17 July 2020

WST13/00010/05

**SSD-5765: various lots; Maloneys Road, Lue; Bowden's Silver Mine**

Figure 2.17
RELOCATED MALONEYS ROAD

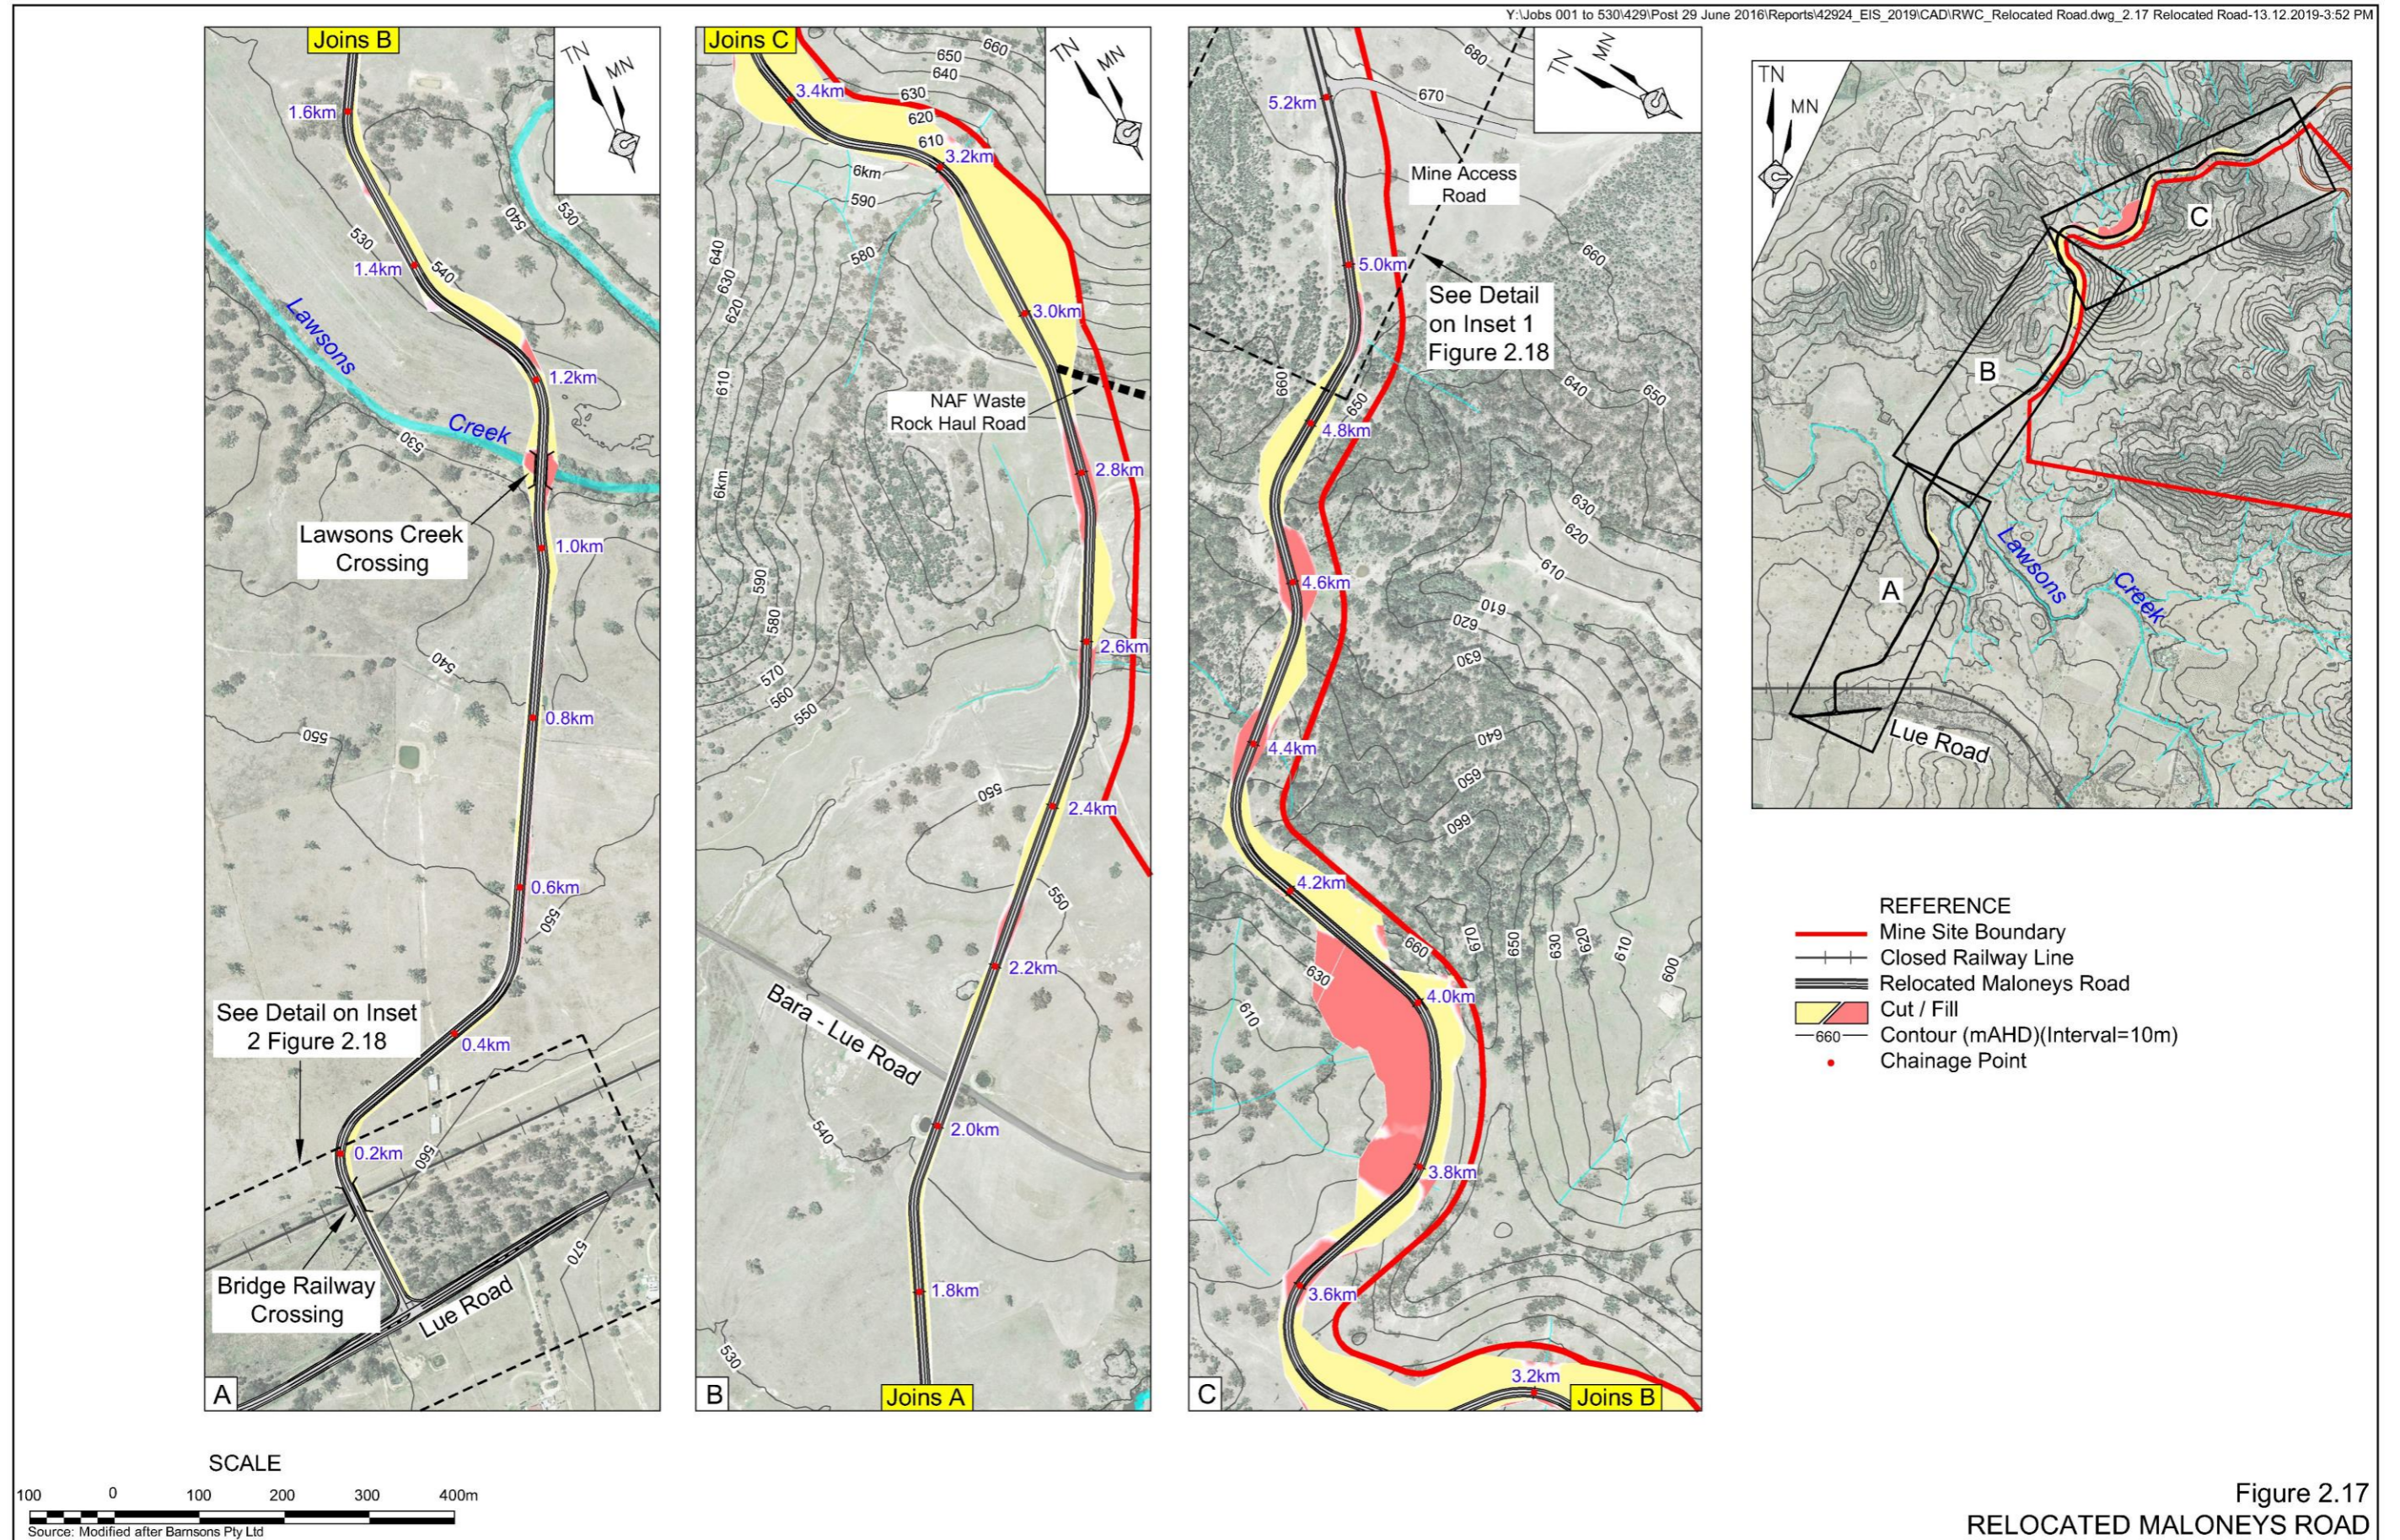
- (a) The EIS includes a proposal to access the rail corridor to construct a new overbridge for the relocated Maloneys Road and all necessary approvals from the managing agent of the CRN on behalf of TfNSW. Our records indicate that JHR, on 16 April 2019, provided Bowden's Silver Pty Ltd a letter approving, in principle, the overbridge, subject to conditions. However, the letter purporting to approve in principle appears to have already expired, as a result of which, it appears invalid to evidence approval in principle. Accordingly, it is advised that the proponent needs to contact JHR to discuss JHR's letter dated 16 April 2019 and provide evidence of JHR's in principle support of the proposal.

- (b) The EIS includes a statement that the new railway crossing would involve the design and construction of a bridge in accordance with the Australian Standard, AS 5100:2017 (Bridge Design) and the CRN construction standard and that the bridge would be a dual lane concrete structure constructed with pre-cast concrete piles, headstocks, deck planks and retaining walls together with appropriate approach earthworks and completed with steel guardrails. Prior to

construction, the Proponent is required to obtain endorsement from JHR and approval from TfNSW to the design and construction of the overbridge as part of a formal application. As such, JHR is not in a position to provide comments on the statement of the design and construction of the bridge at this stage. For the avoidance of doubt, please note this letter does not constitute a final approval from TfNSW in respect to the construction of an overbridge over the rail corridor.
